Rezoning Transportation Analysis

Petition Number: #2022-044

Date	Description
08-19-2022	First Review (AO)
09-22-2022	Second Review (AO)

RZ-1

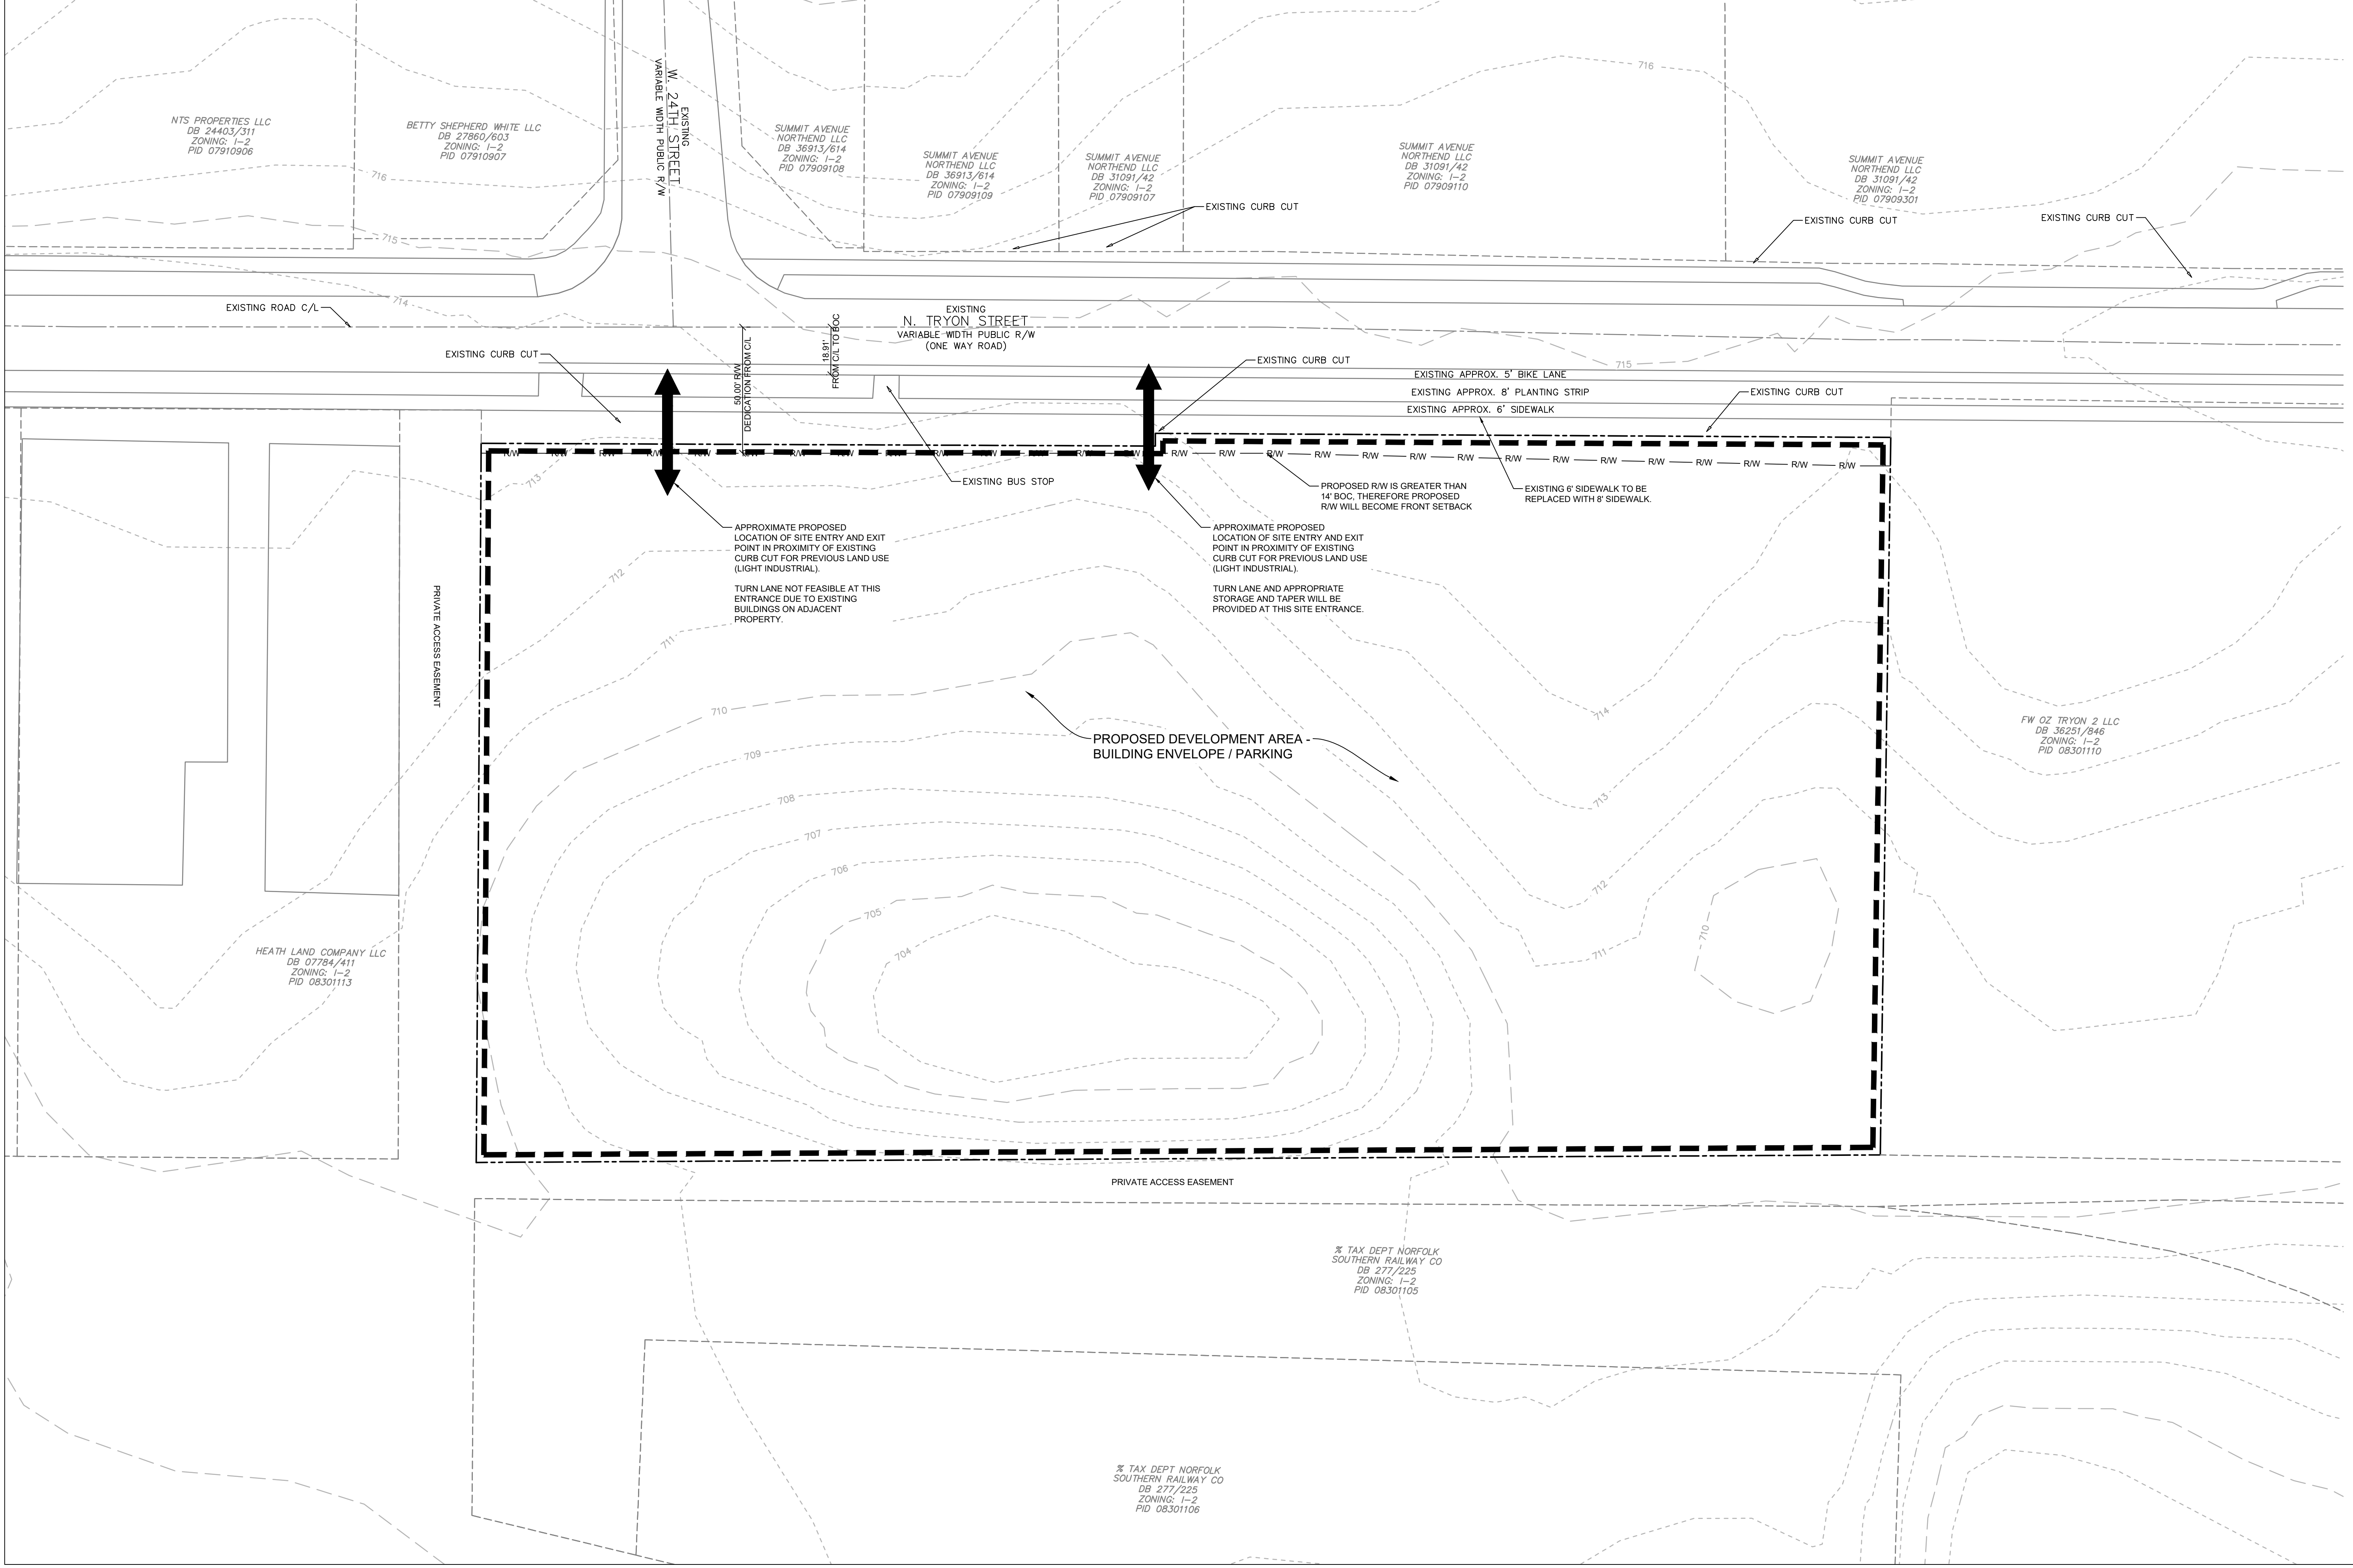
6. **Outstanding Comment from 8-19-22:** Revise site plan and conditional note(s) to commit to constructing a right turn lane with 100' of storage and appropriate taper on N Tryon St at proposed access points per NCDOT requirements.

Update to Comment (New Site Plan, 9-12-22): If a turn lane can't be provided at the site access it must be removed from the Rezoning Plan per NCDOT. It appears that further coordination with NCDOT is required. Include a layout of the proposed right turn lane on site plan.

10. **New Comment (New Site Plan, 9-12-22):** Revise site plan removing existing driveway cuts only showing proposed access points for clarity. Note that existing curb cuts are to be removed

11. **New Comment (New Site Plan, 9-12-22):** Revise Transportation note IV.a.to add NCDOT in addition to CDOT.
